Lynnyrd Wolfe

From: Laura Gibbons
Sent: 25 April 2019 14:19
To: Nick Dyde
Cc: Laura Humphries; Michael Eastham; Pete Hodgson
Subject: RE: Ashdown Vale Barnham - Retaining Walls

External Levels & Features Layout
Sheet 3 of 3

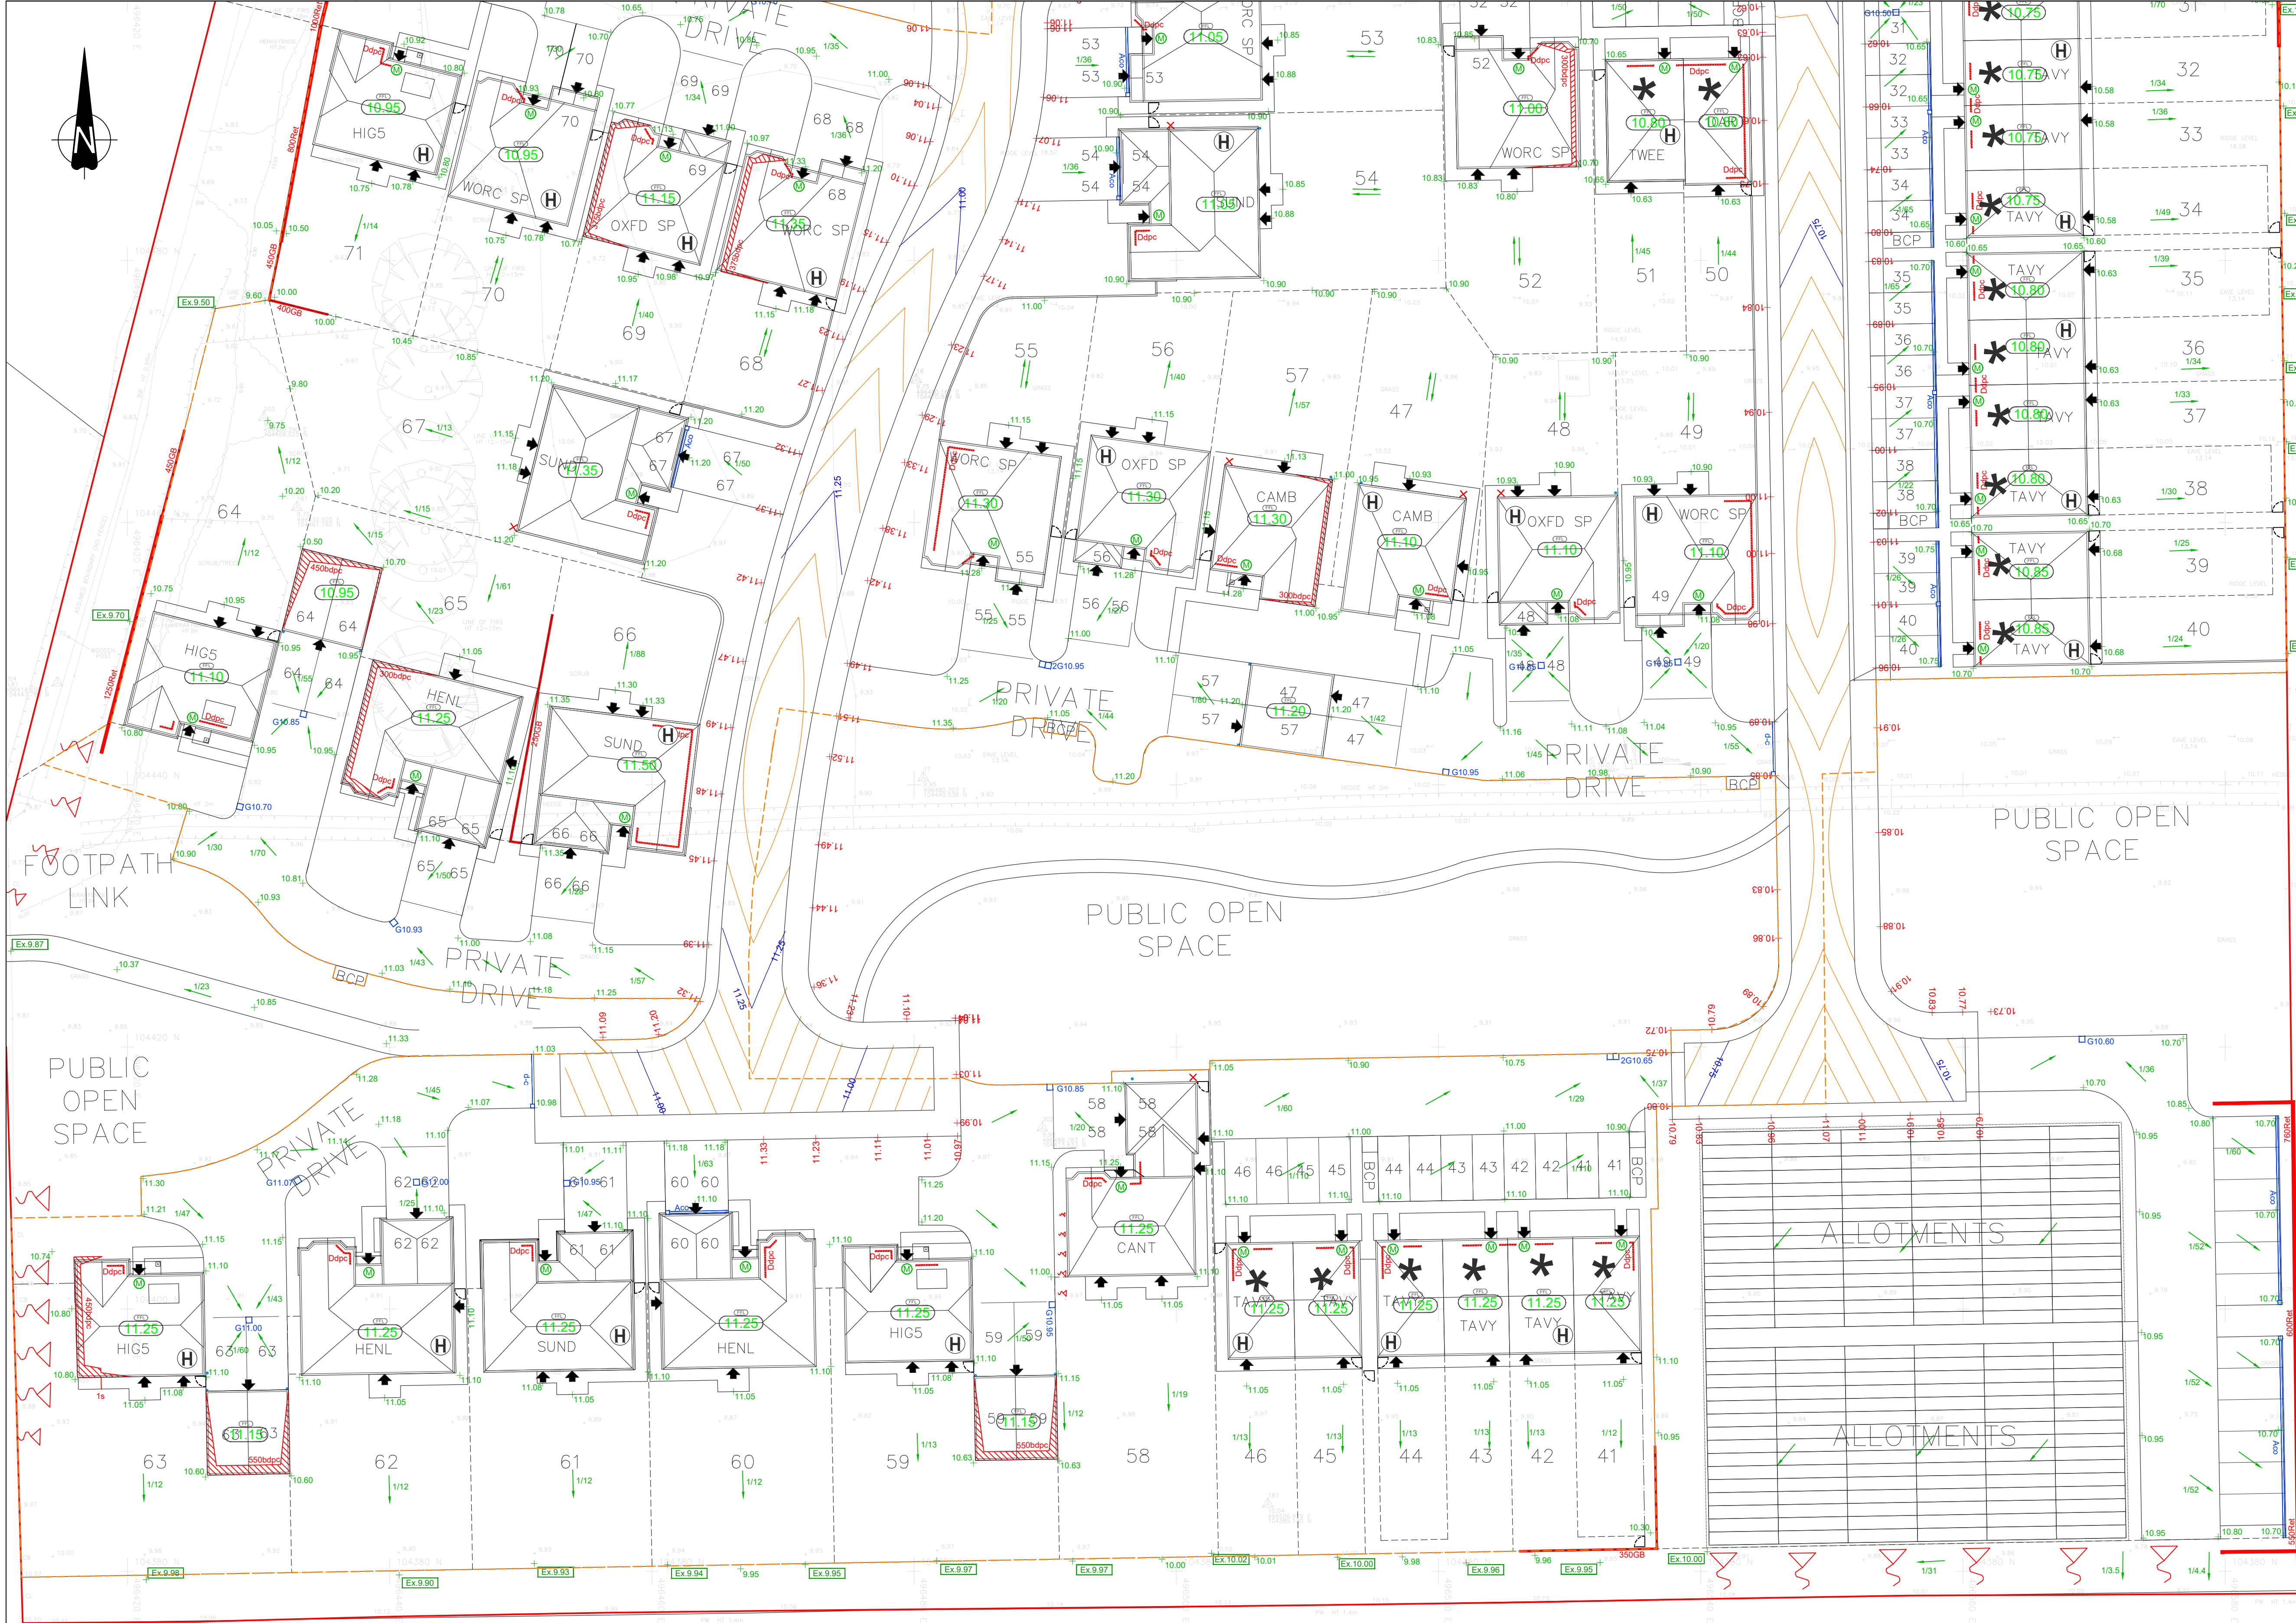
I note the plan states that the slope of gardens at 92-93 has increased where the retaining walls are no longer required. I would like to see a gravel margin included where any revised slopes are effectively directing surface water runoff to neighbouring land.

The proposed wall at plot 88 will be okay with the proposed gravel margin.

Please send through revised construction detail drawings and layout.

The structural drawing has been updated to indicate weepholes and the gravel margins please see attached. Once the civils drawings have been finalised the retaining wall locations will need updating to suit.

Drainage Maintenance Plan
Sheet 1 of 2

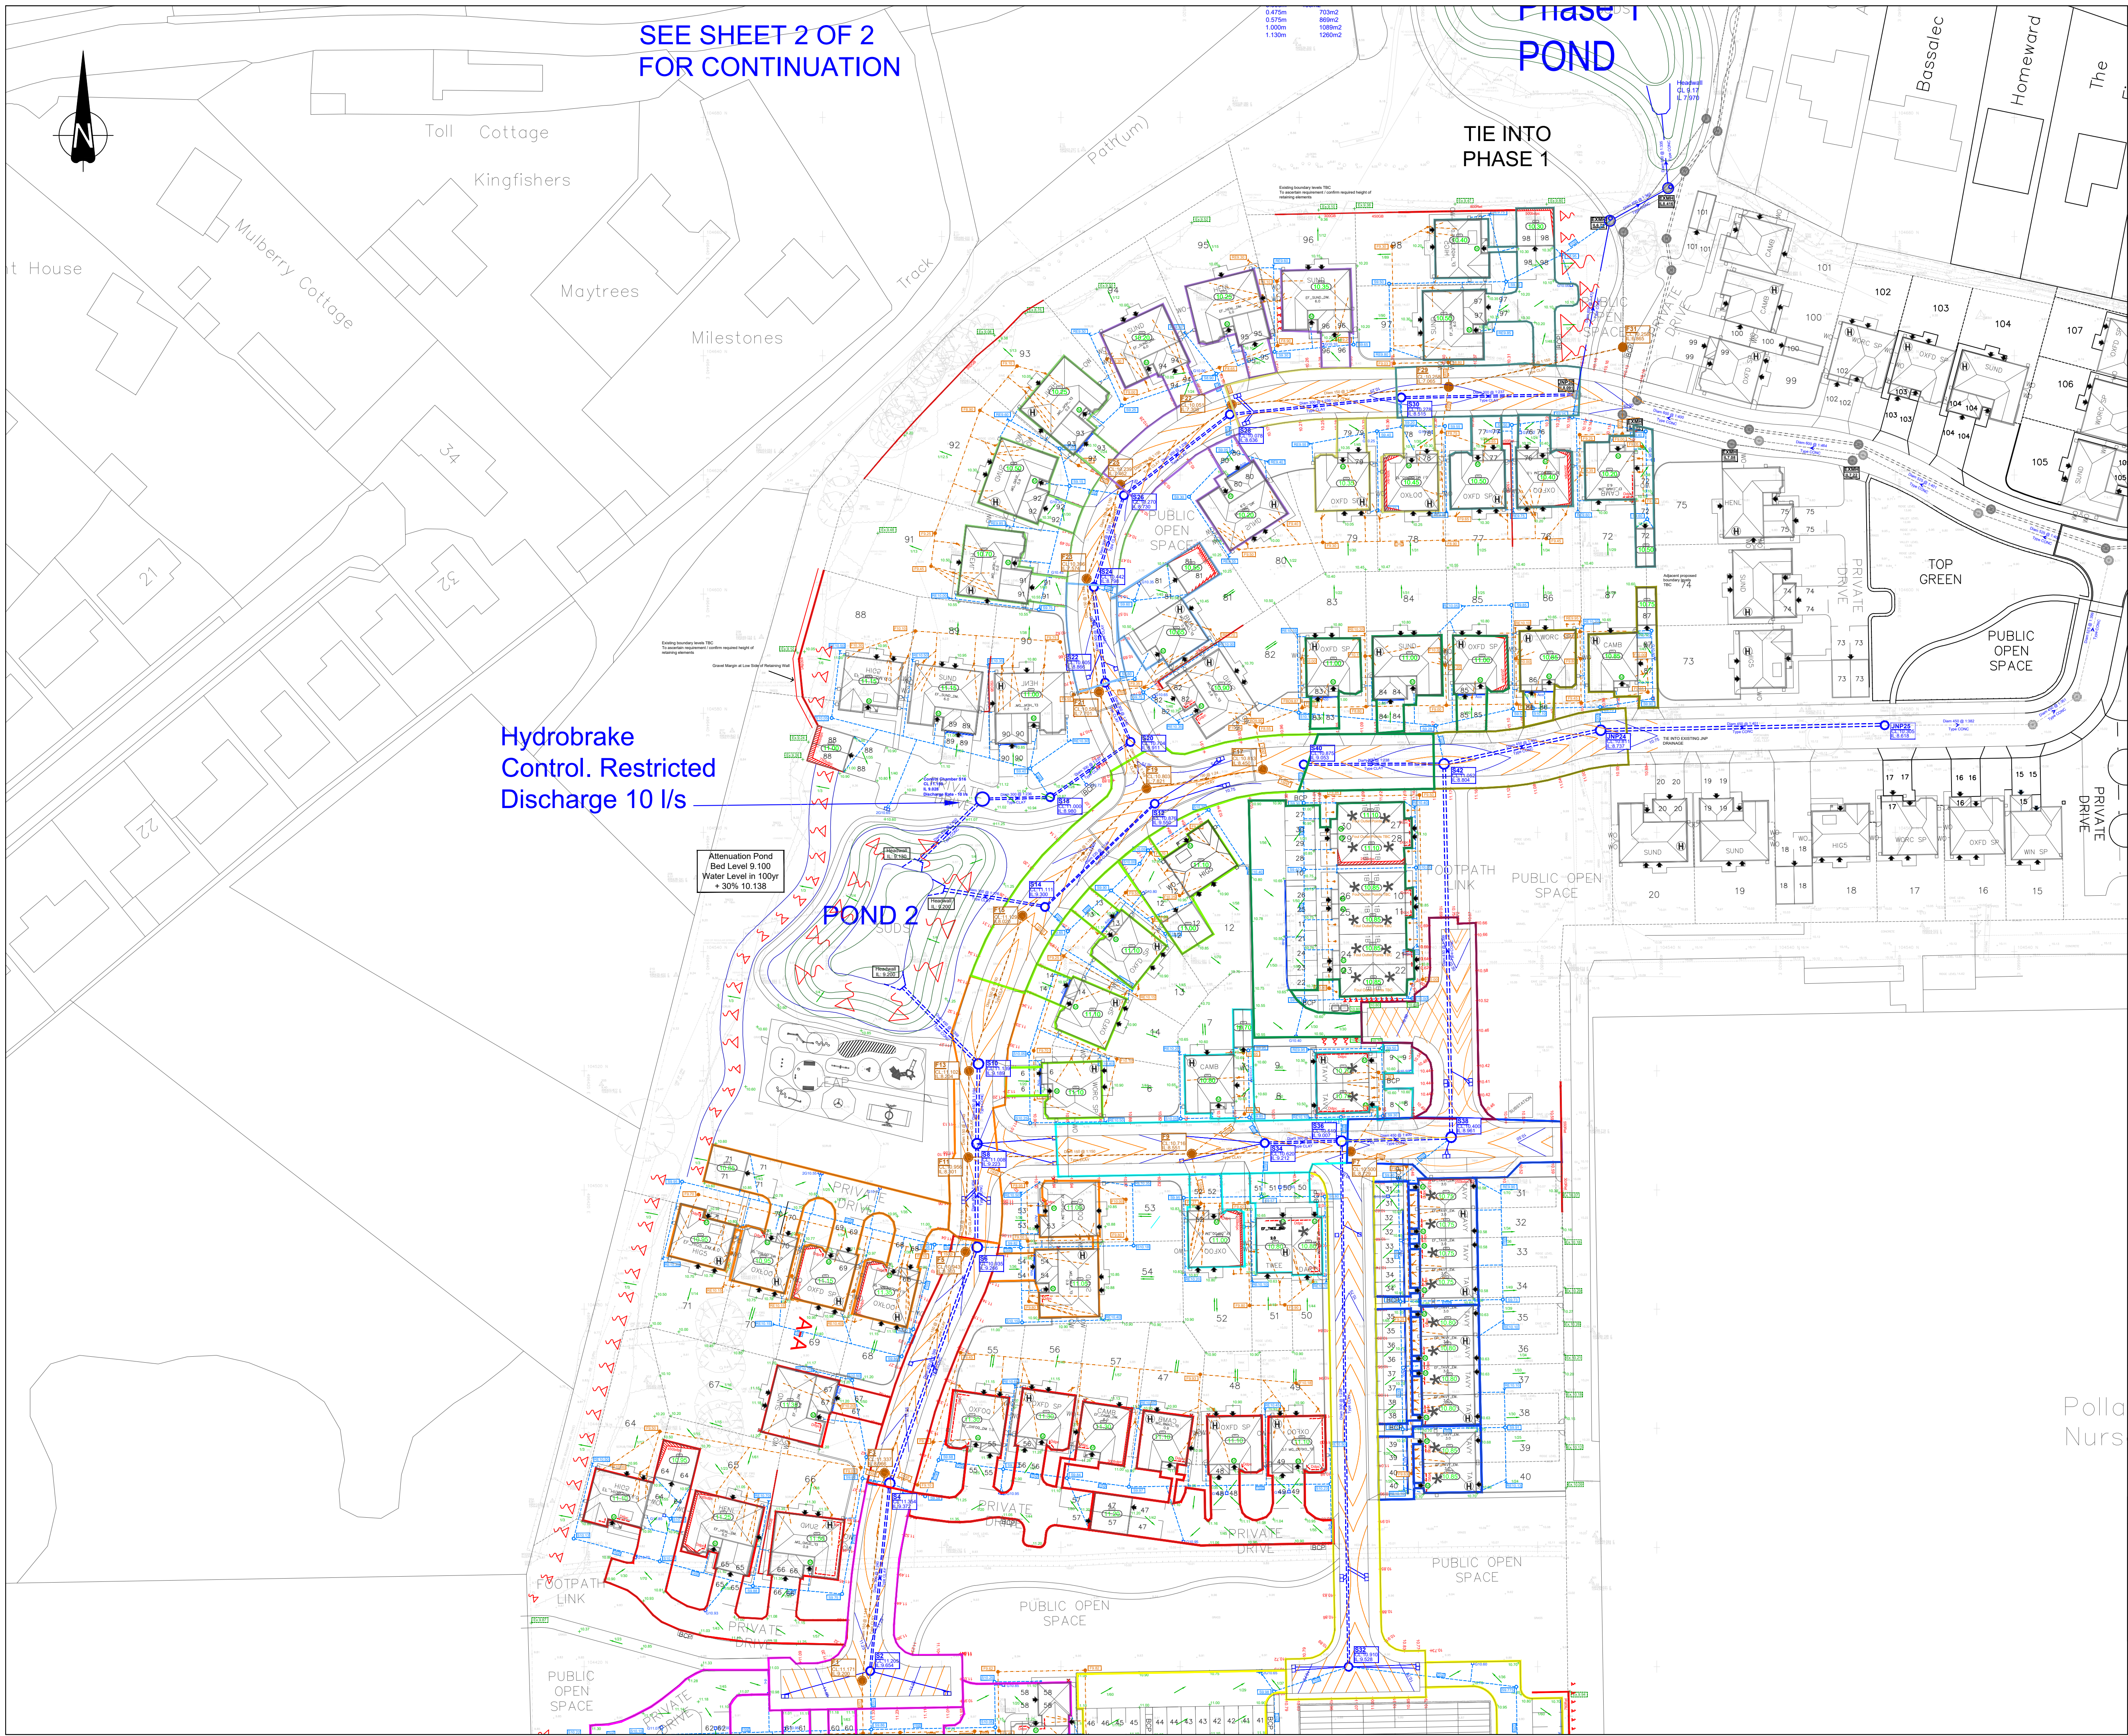
Thank you for sending through the maintenance statement. The maintenance statement needs to state how the work will be funded. I.e. will a charge be levied on residents?

Please can it also be explicitly stated that Redrows will have riparian responsibility for the section of ordinary watercourse that abuts their land.

If details can also be added regarding any requirements for maintenance of the retaining wall structures and their gravel margins.

On a slightly separate note, please can you confirm the extent to which the surface water drainage network is to be adopted.
